# KITITAS COUNTY

### MEMORANDUM

TO: All Staff  
FROM: Justin Turnbull, County Surveyor   
DATE: March 16, 2020  
SUBJECT: County Survey Review of SPF-20-00002 Dunford  
(The Cabins at the Farm)

#### Comments for Preliminary Subdivision

### DUNFORD LARGE LOT SUBDIVISION

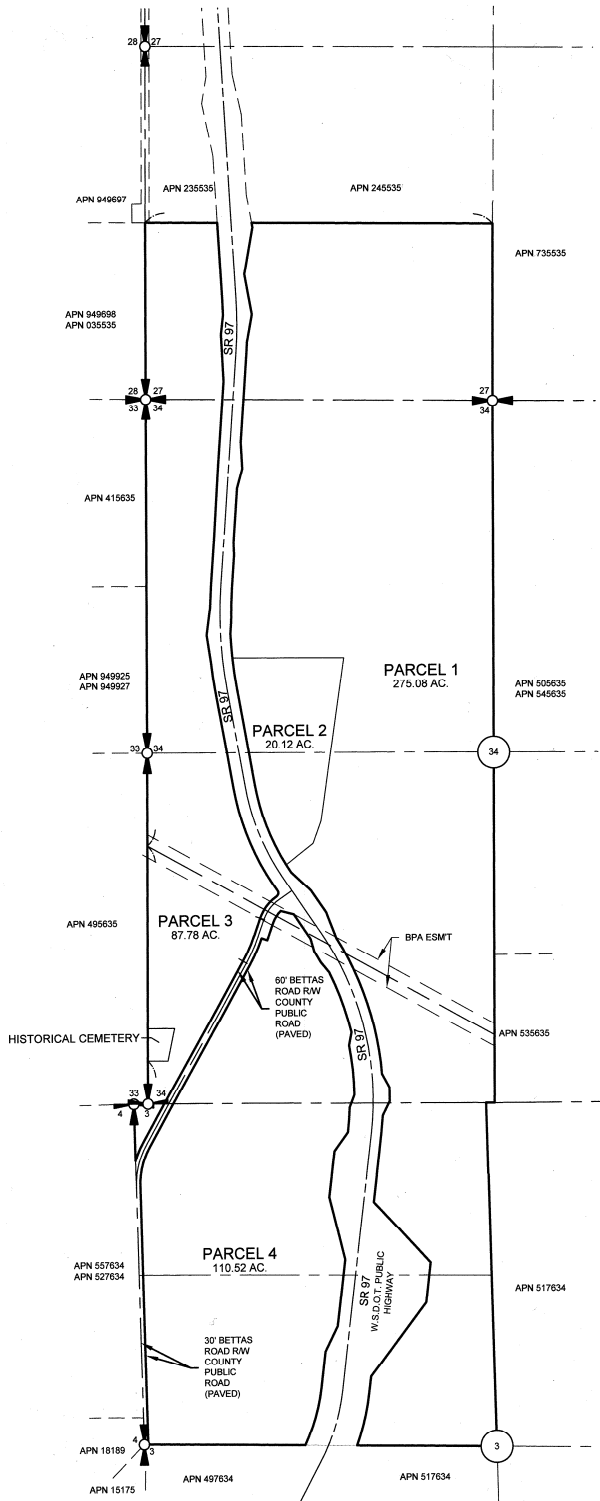
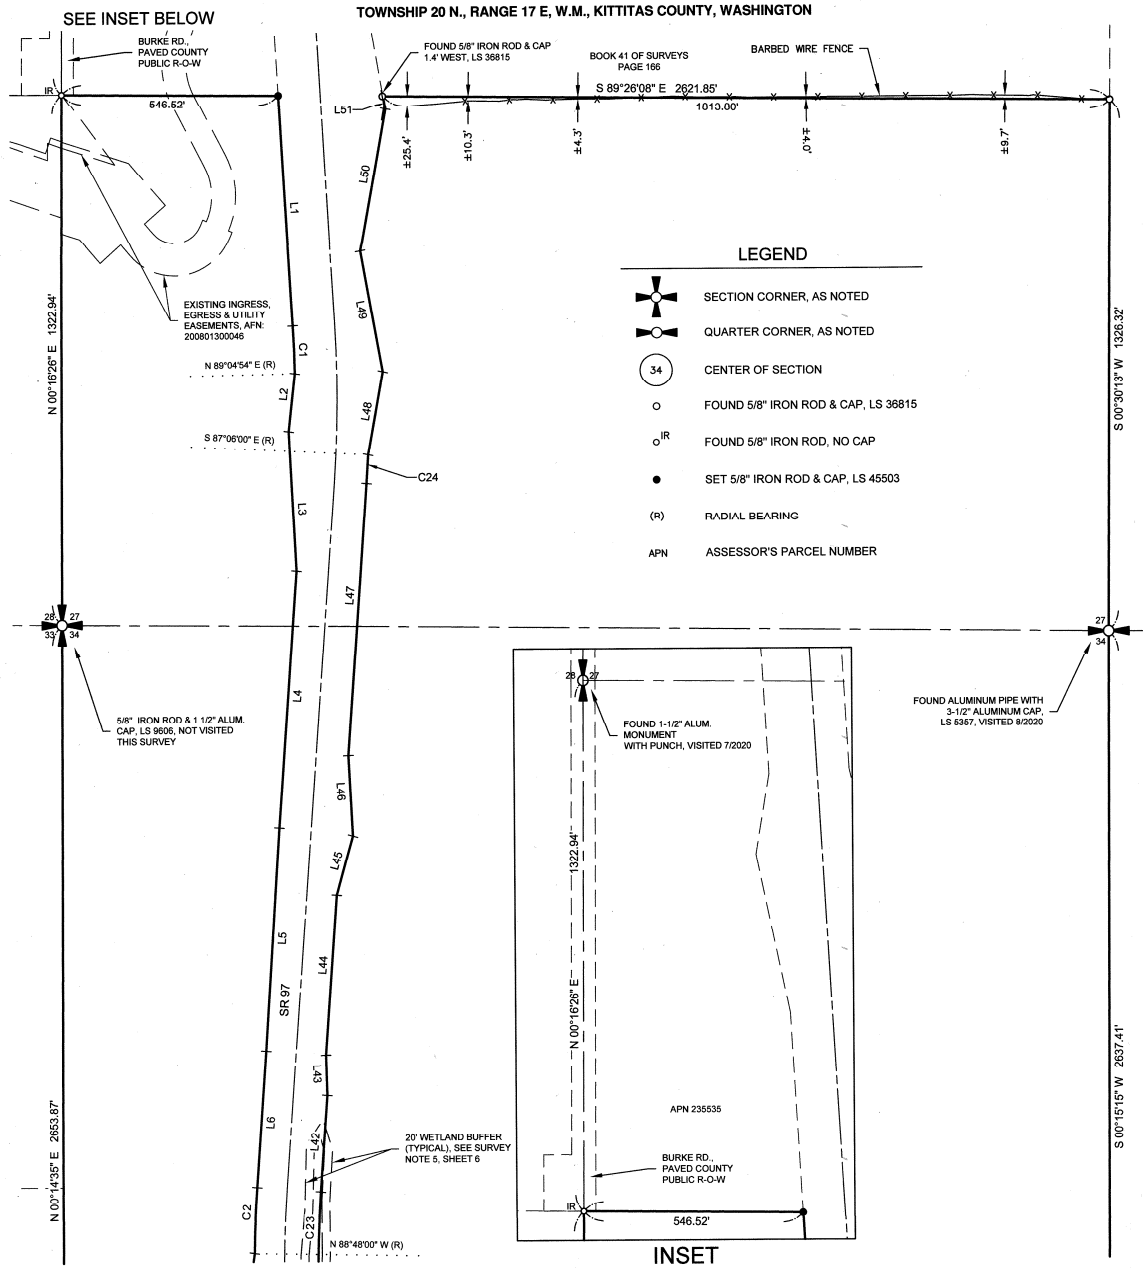
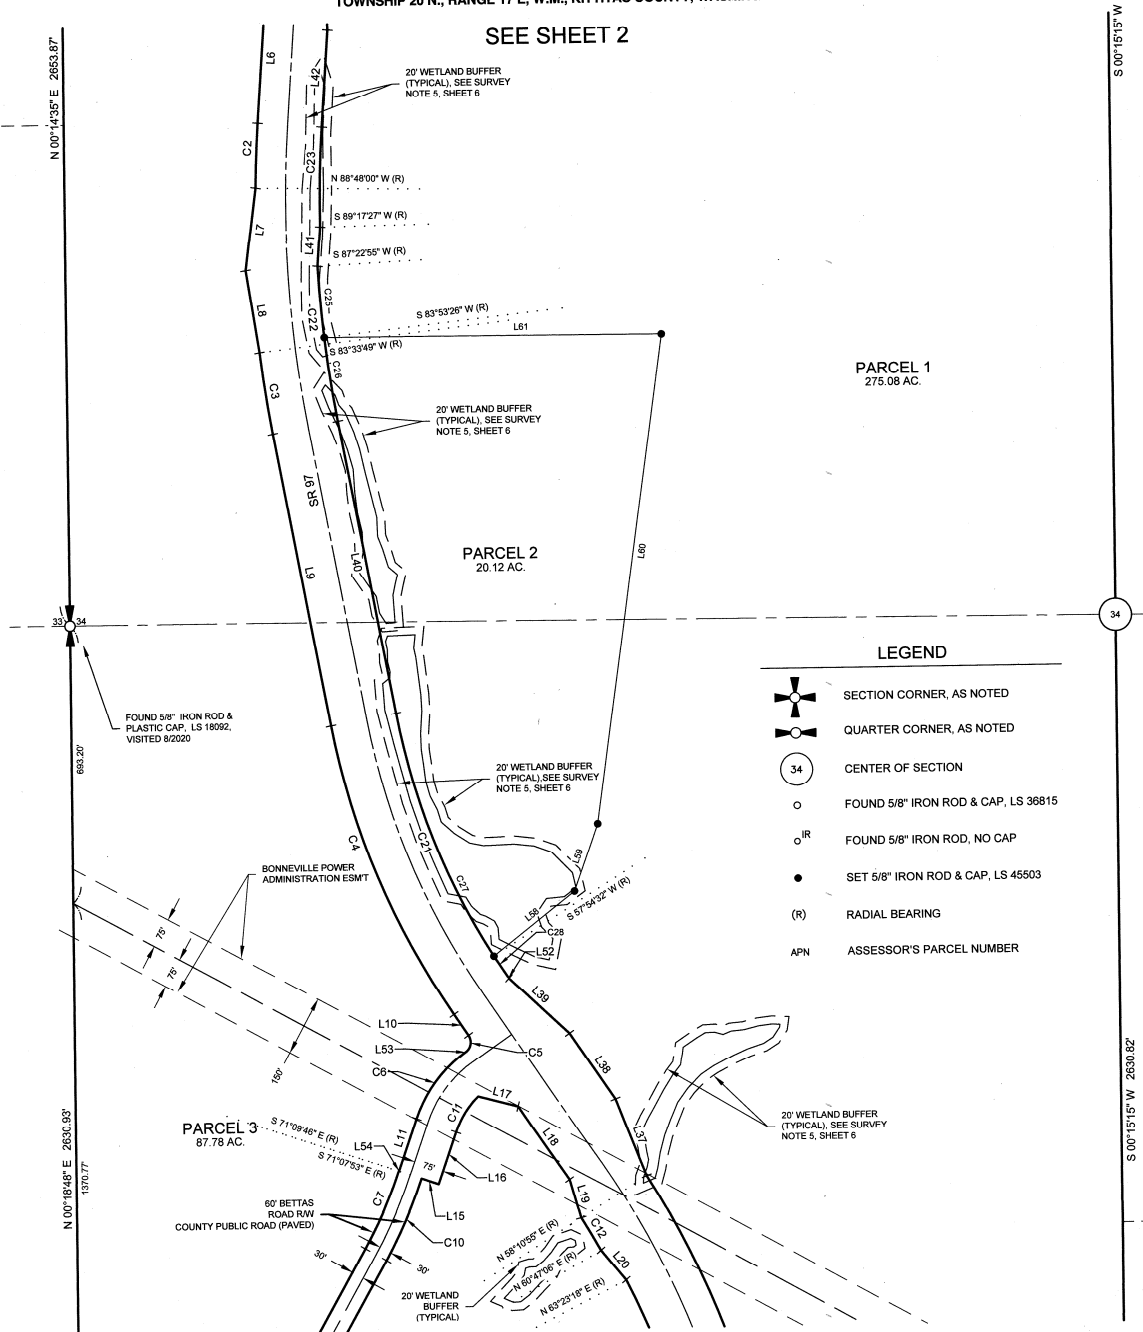
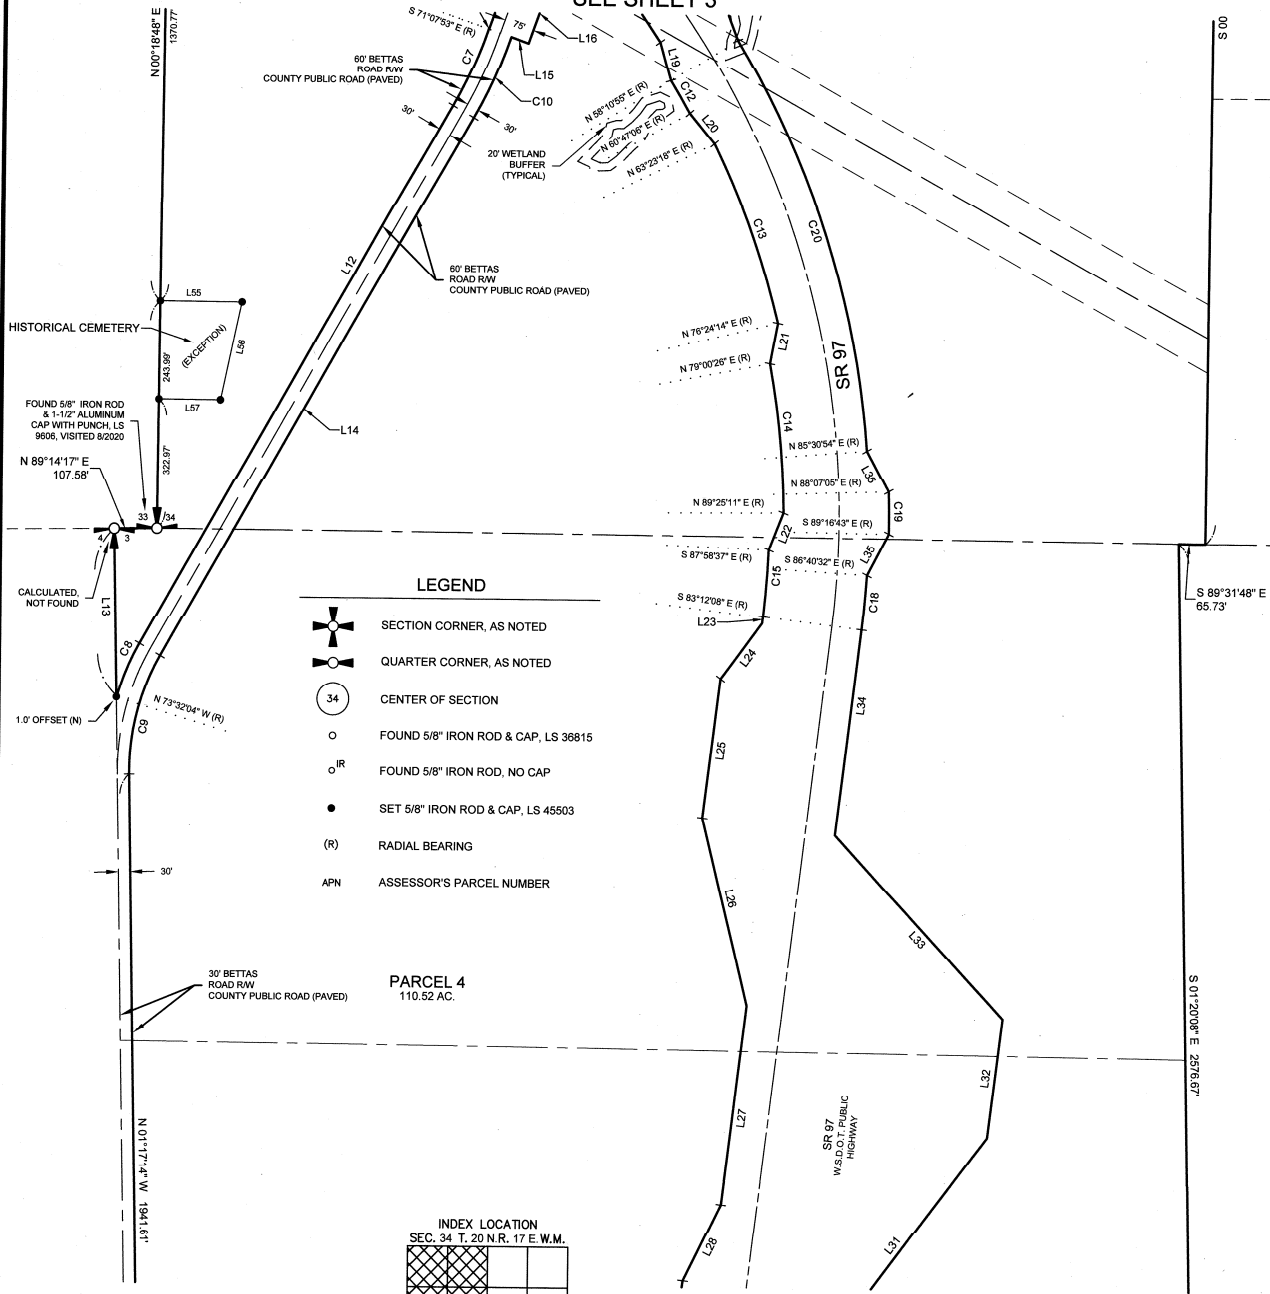
9. Equipment procedures statement must be shown.
10. Auditors statement must be shown.
11. Surveyors statement must be shown.
12. The purpose of survey statement must be shown.
13. The basis of bearings must be addressed.
14. The survey control held for the project must be addressed.
15. Set property corners must be shown.

DUNFORD PRELIMINARY LARGE LOT SUBDIVISION

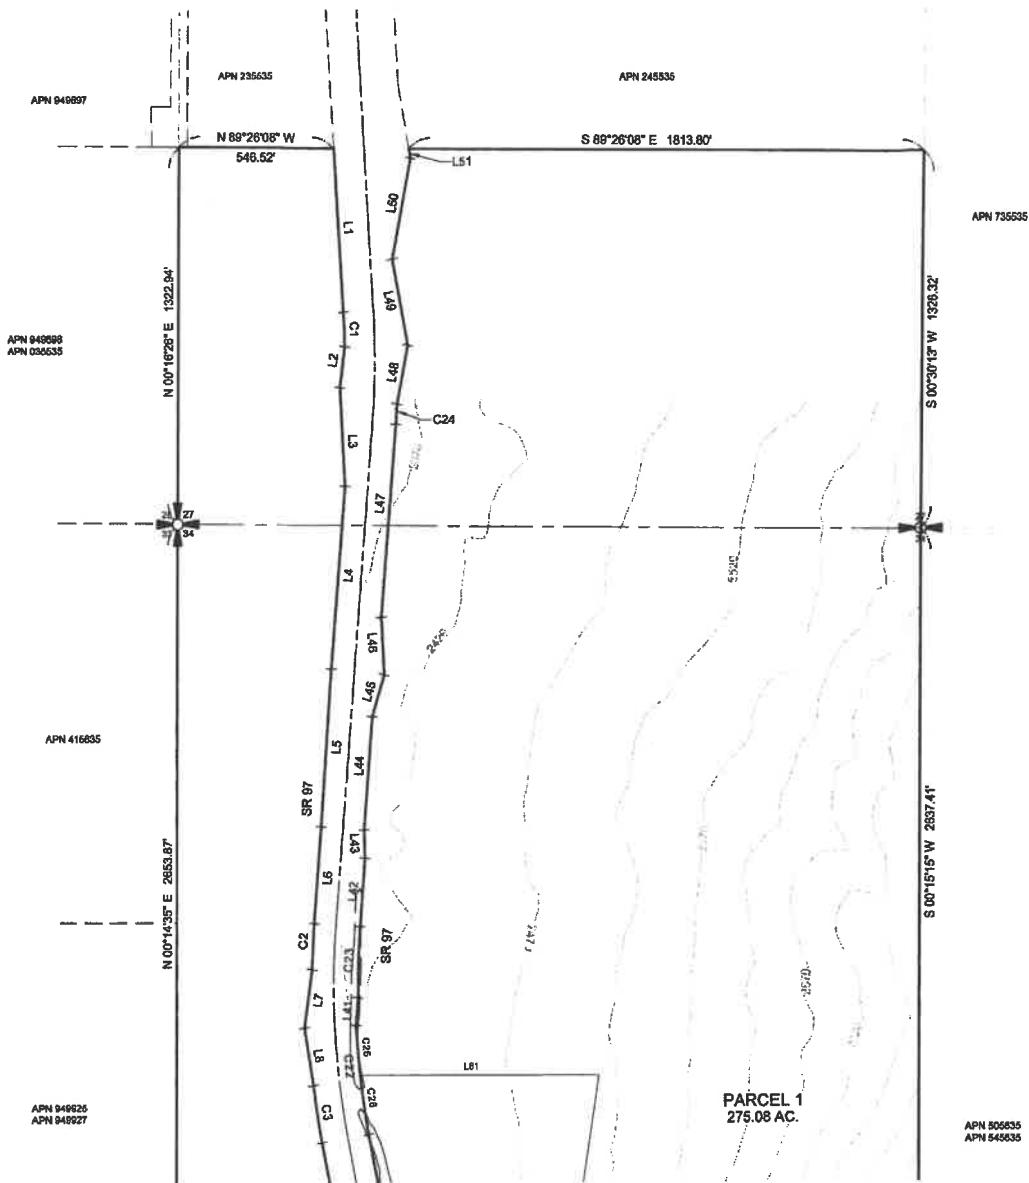
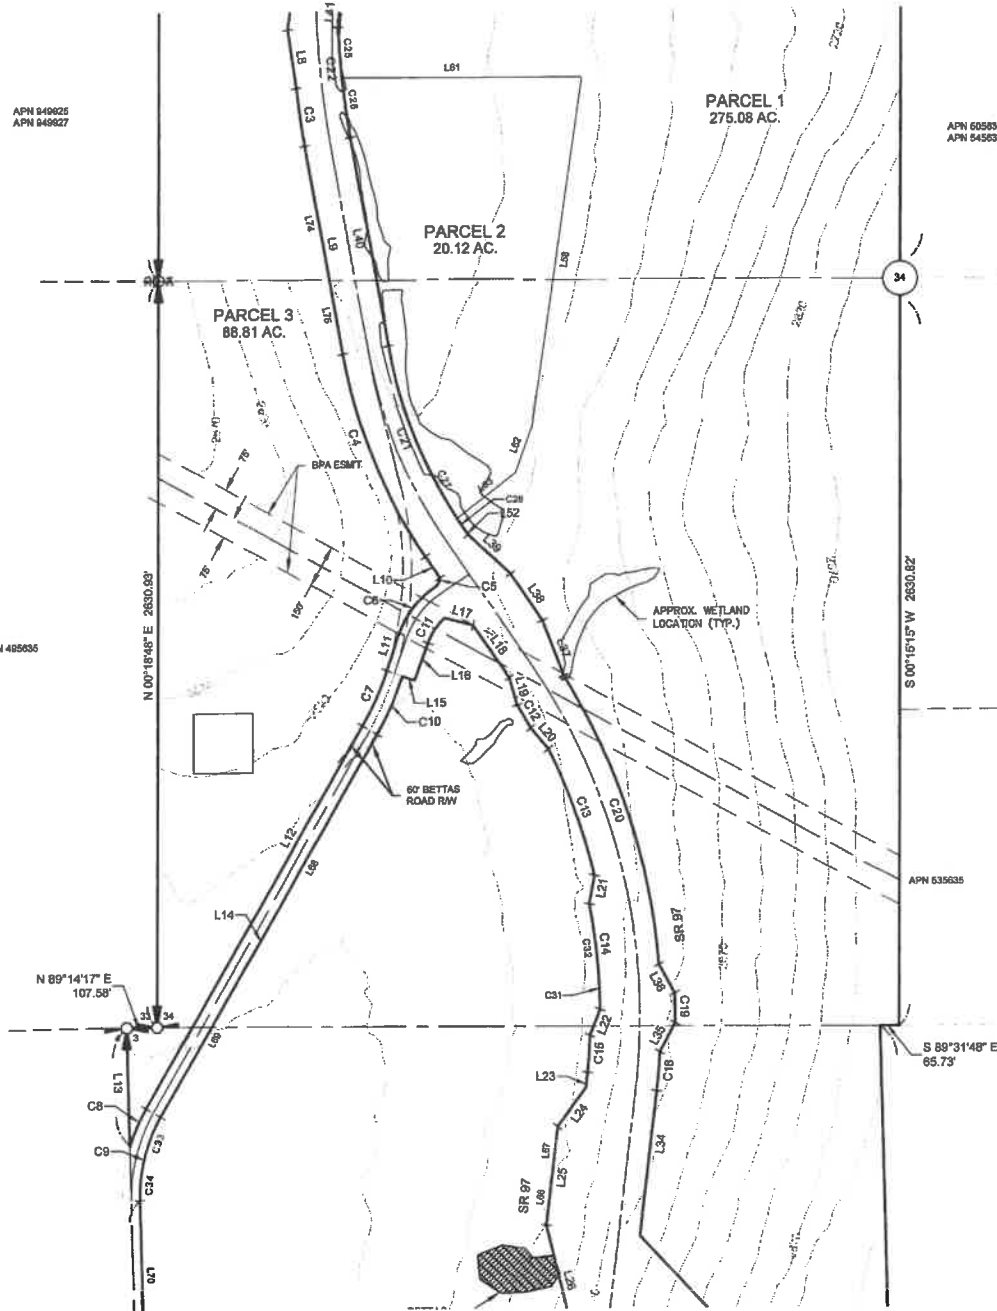
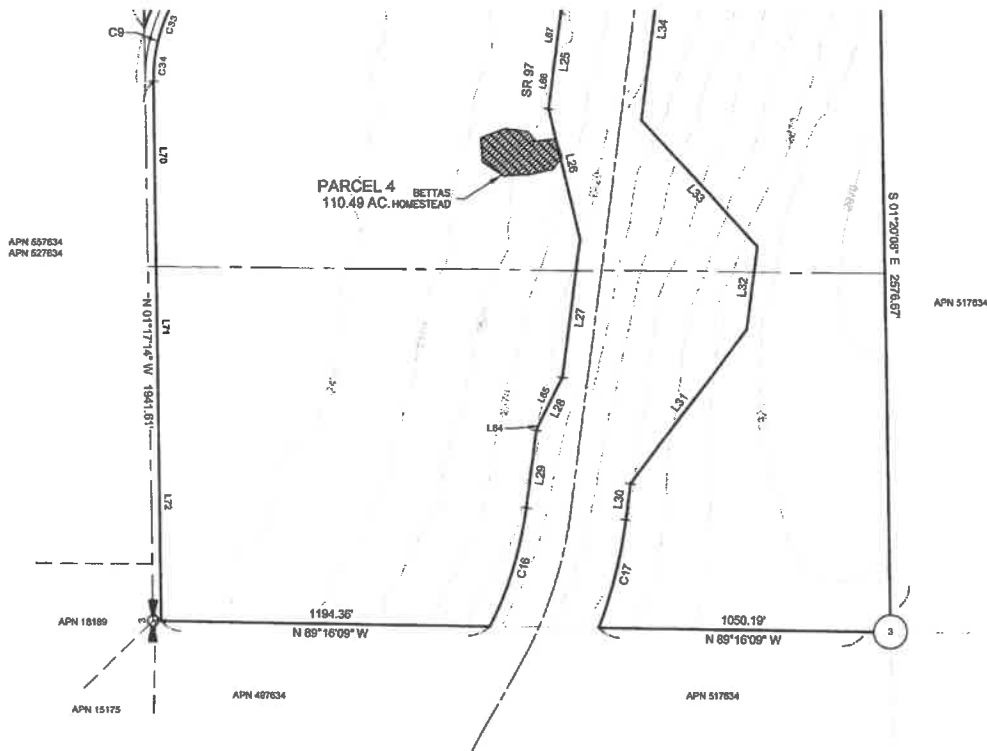
1. The submittal does not address the topo requirements of WAC:332-130-145.
2. The submittal does not include a legend.
3. The areas identified as wetlands obscure a number of line labels.
4. The areas identified as wetlands should include the source of the wetland information (County GIS?, Fish and Wildlife Inventory?, field locate by XXX?)
5. The dashed line near the intersection of Bettas Road and SR 97 is not identified. (Easement?)
6. The box near the SE corner of Parcel 3 is not identified.
7. Bettas Road should be identified as being paved county right of way.
8. SR97 should be identified as state Right of Way.
